## Deadline 4 – Table of DCO amendments

<b>PINS Reference</b>	EN010072	
<b>Document No.</b>	SPH_GREX_DCOD4_03	
<b>Authors</b>	BURGES SALMON LLP	
<b>Revision</b>	<b>Date</b>	<b>Description</b>
0	26 May 2016	Issued

## Table of DCO Amendments requested - Submitted for Deadline 4

### Indicative Elevations & Section of Penstock Configuration (Revision 1)

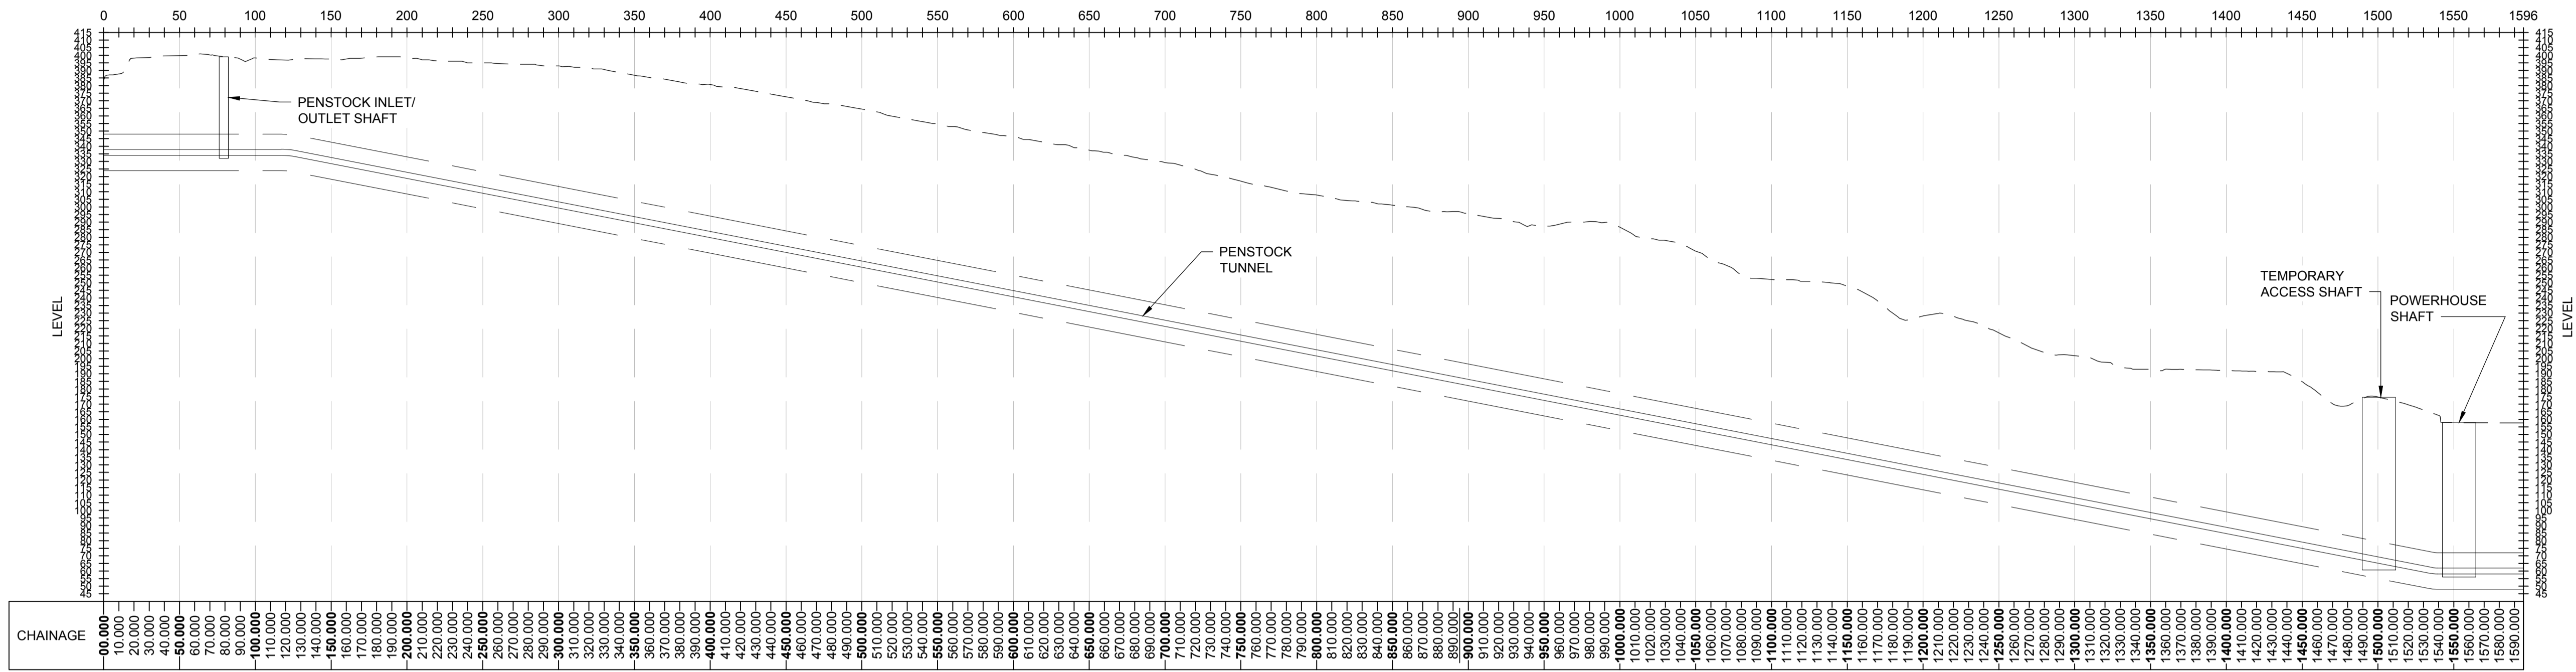
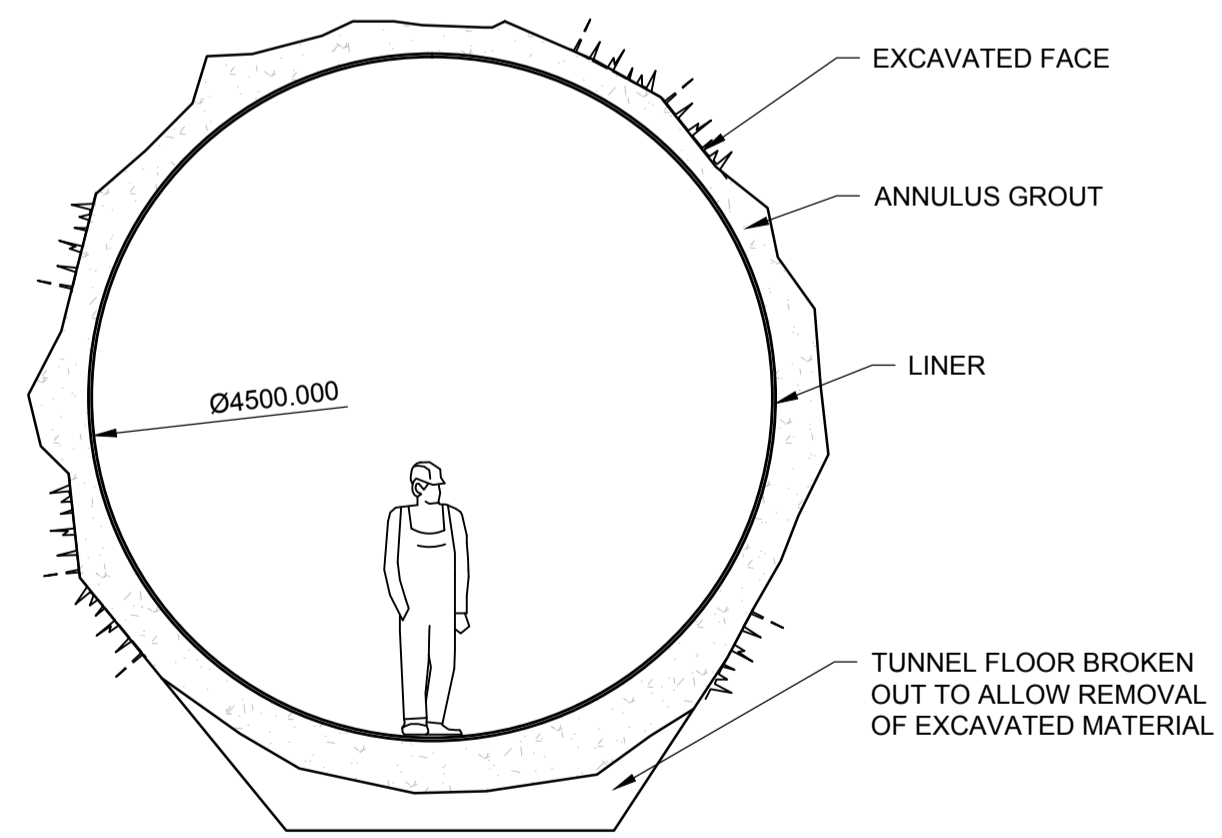
2.3	Requirement 5(1), detailed design parameters	Following review of the parameters by the engineer it was noted that the incorrect figure had been given for pipe diameters, as shown in the indicative drawings the correct figure is 900mm and only one pipe is required.	<p>Requirement 5(1) is amended as follows:</p> <table border="1"> <tr> <td>1A</td> <td>Q1 <del>spillway</del><u>Scour/ discharge</u> infrastructure <del>(Input)</del></td> <td></td> <td></td> <td></td> <td><del>800mm</del> <u>900mm</u> (Maximum pipe diameter)</td> </tr> <tr> <td><del>1A</del></td> <td><del>Q1 spillway</del> infrastructure <del>(output)</del></td> <td></td> <td></td> <td></td> <td><del>450mm</del> <del>(Maximum pipe diameter)</del></td> </tr> </table>	1A	Q1 <del>spillway</del> <u>Scour/ discharge</u> infrastructure <del>(Input)</del>				<del>800mm</del> <u>900mm</u> (Maximum pipe diameter)	<del>1A</del>	<del>Q1 spillway</del> infrastructure <del>(output)</del>				<del>450mm</del> <del>(Maximum pipe diameter)</del>

1A	Q1 <del>spillway</del> <u>Scour/ discharge</u> infrastructure <del>(Input)</del>				<del>800mm</del> <u>900mm</u> (Maximum pipe diameter)										
<del>1A</del>	<del>Q1 spillway</del> infrastructure <del>(output)</del>				<del>450mm</del> <del>(Maximum pipe diameter)</del>
